Case Officer: Gemma Magnuson

Applicant: Bicester Hotel, Golf and Spa

Proposal: Erection of new building to accommodate a new cafe, pro shop, indoor practice room, lockers and viewing gallery

Drawing Title:  
**Site and Location  
Plans**

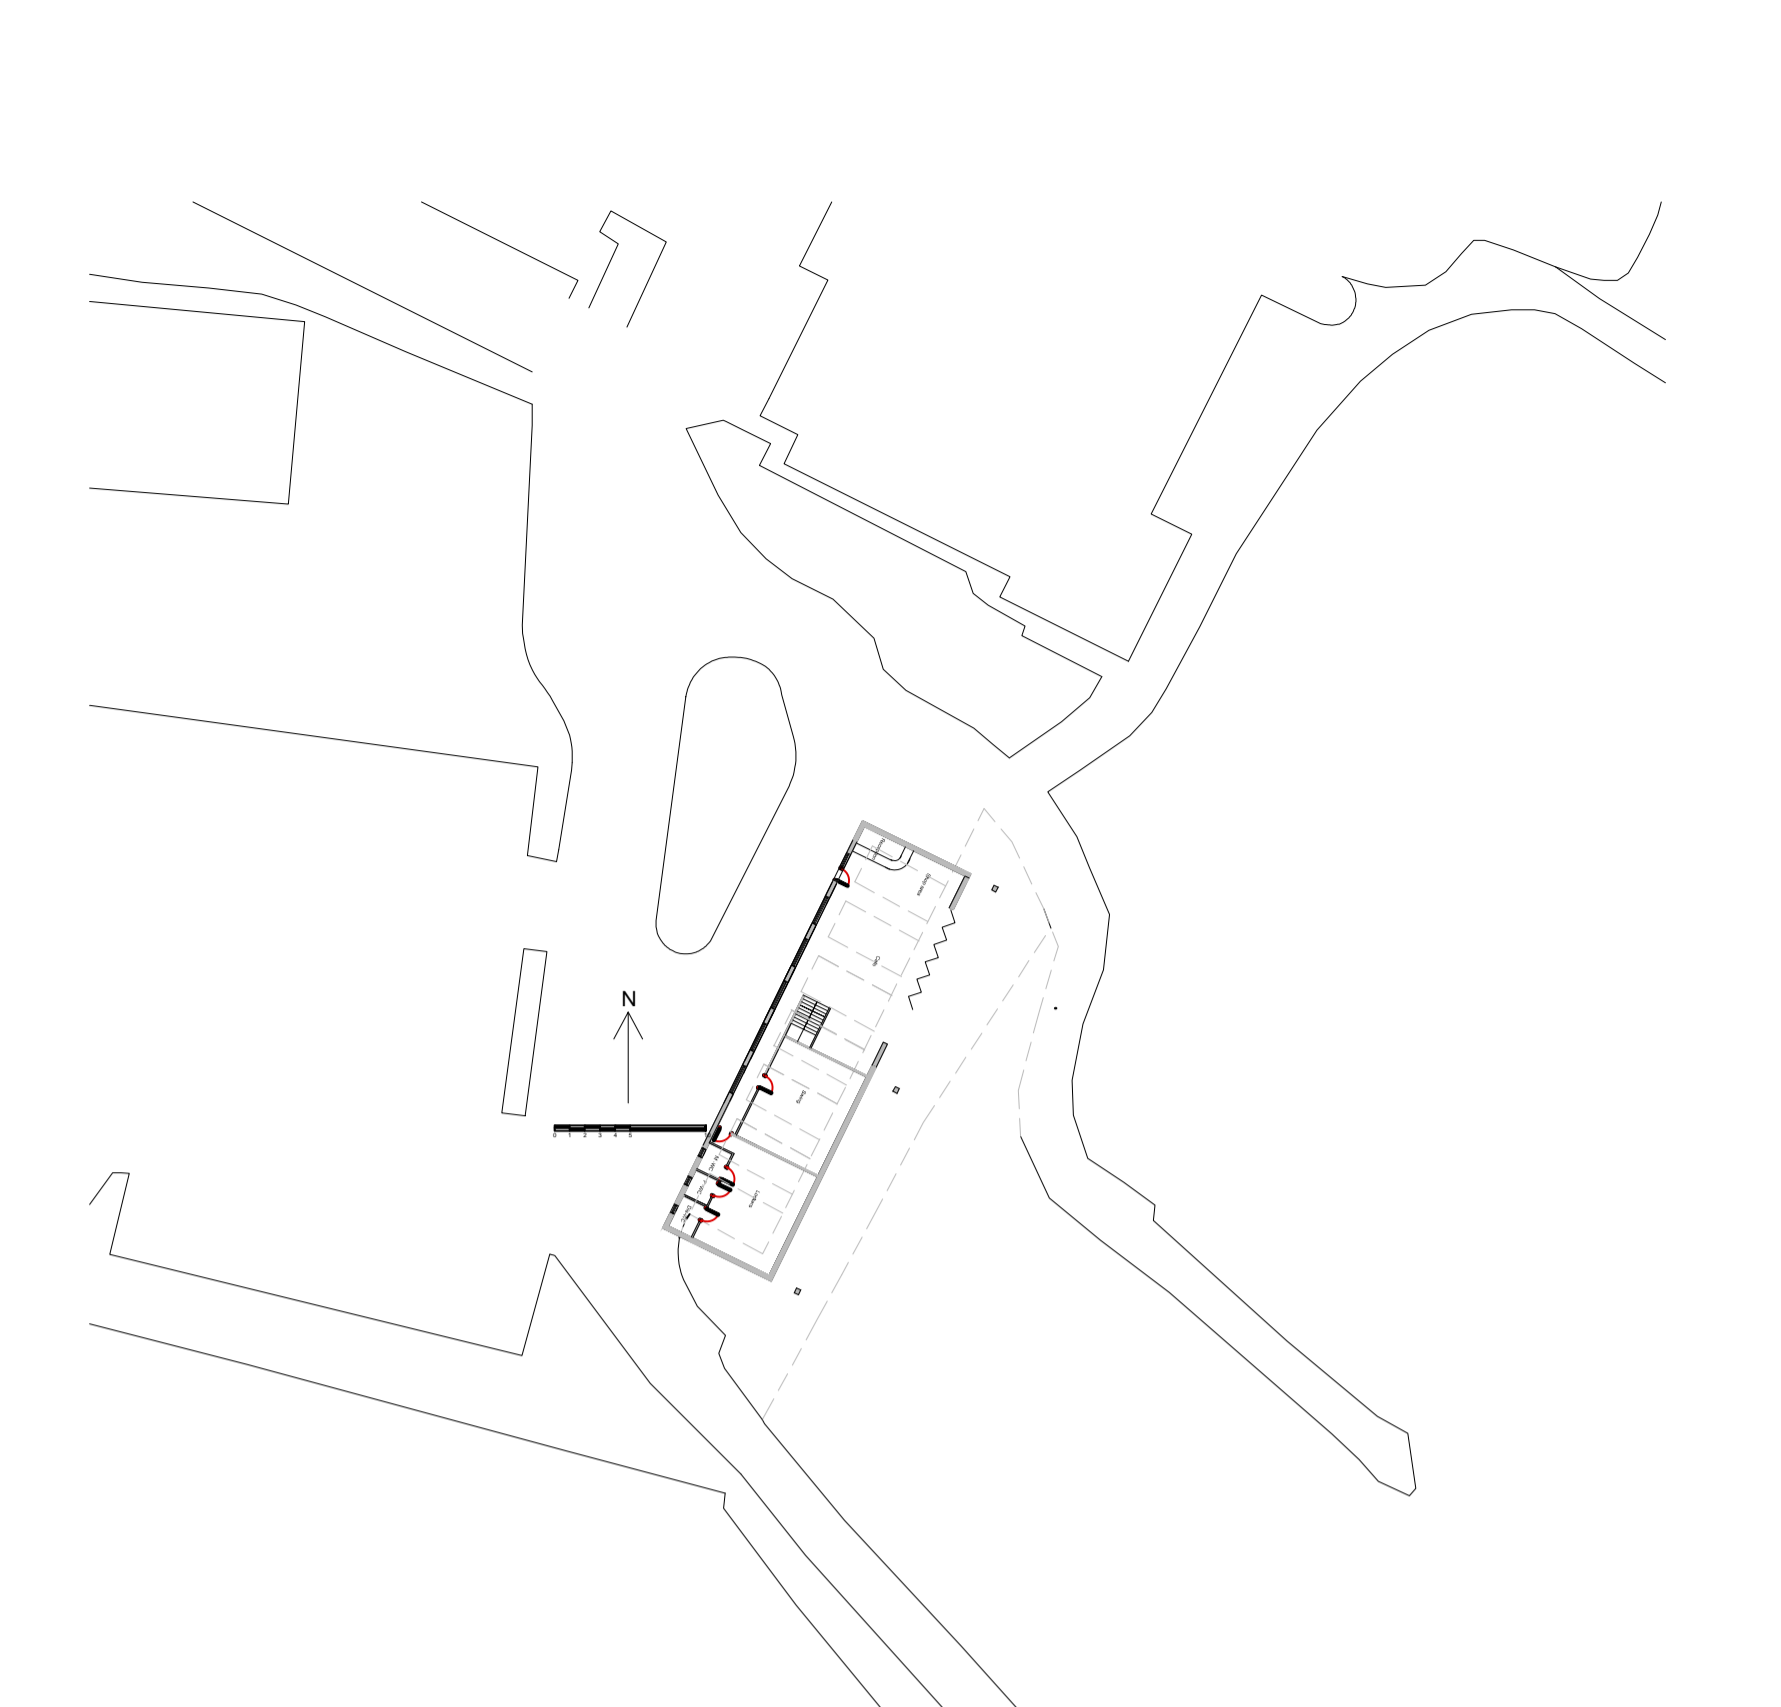
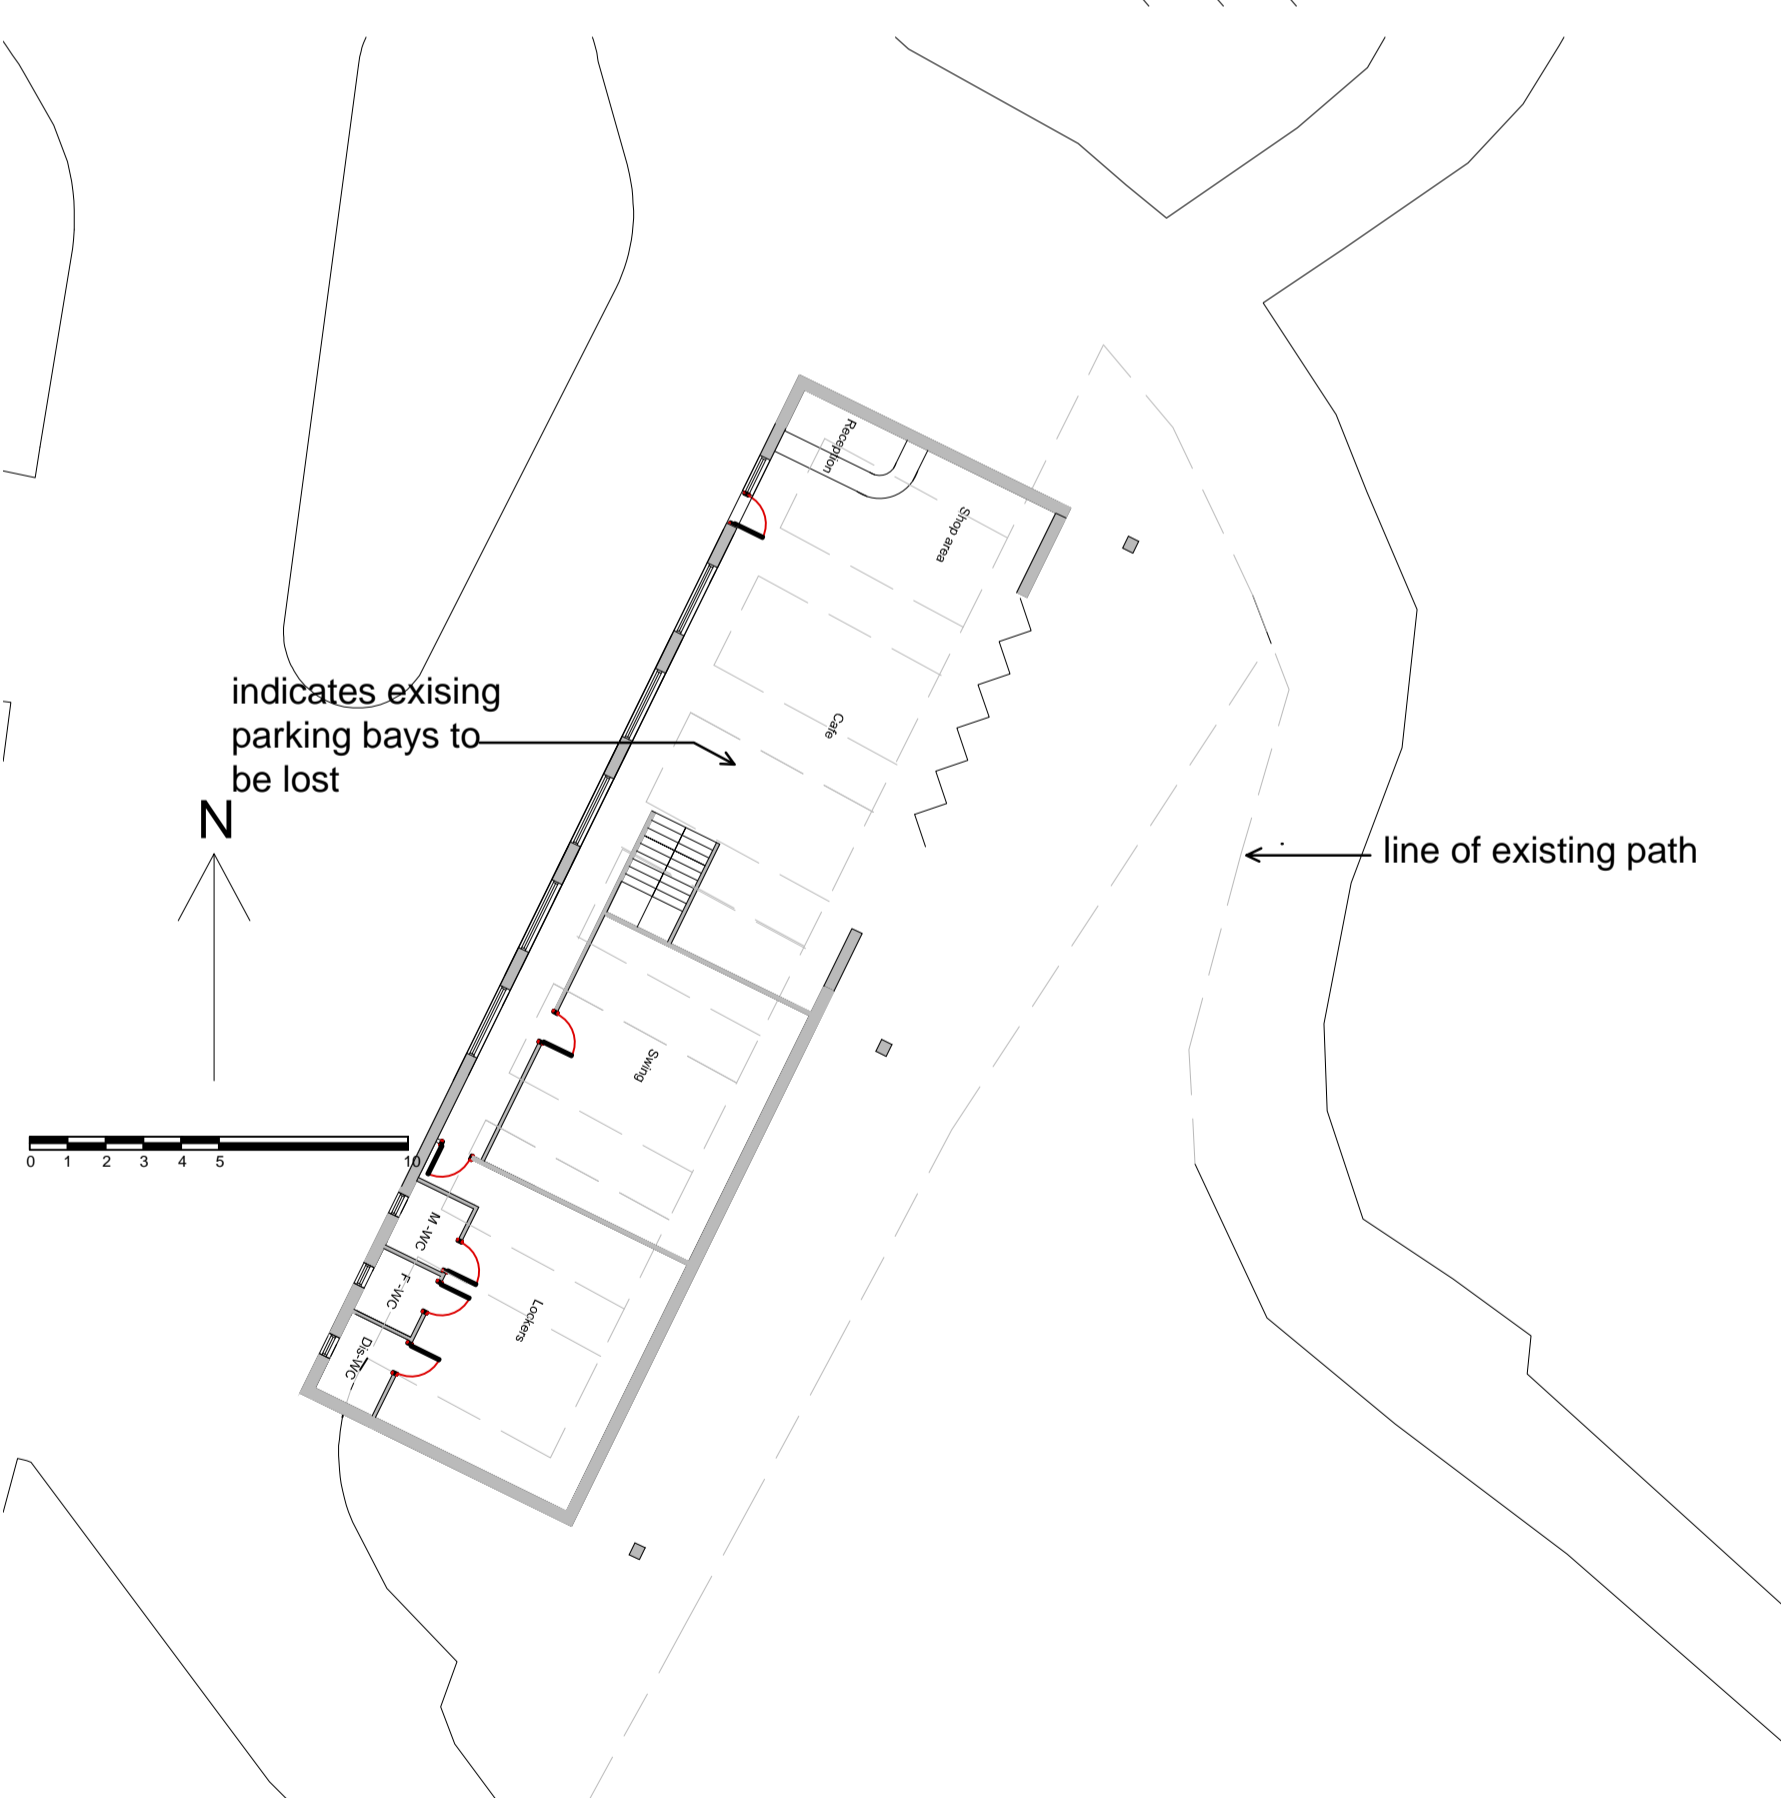
8.16. The proposed building would not be constructed upon the public right of way and a diversion would therefore not be required. The development would result in the loss of existing parking spaces although I note that the Local Highway Authority has raised no objection in terms of highway safety. During my site visit I noted that these are the parent and child parking spaces, and that the site benefits from an existing large car park. I therefore agree with the assessment of the LHA and consider the proposal to accord with the above Policies.
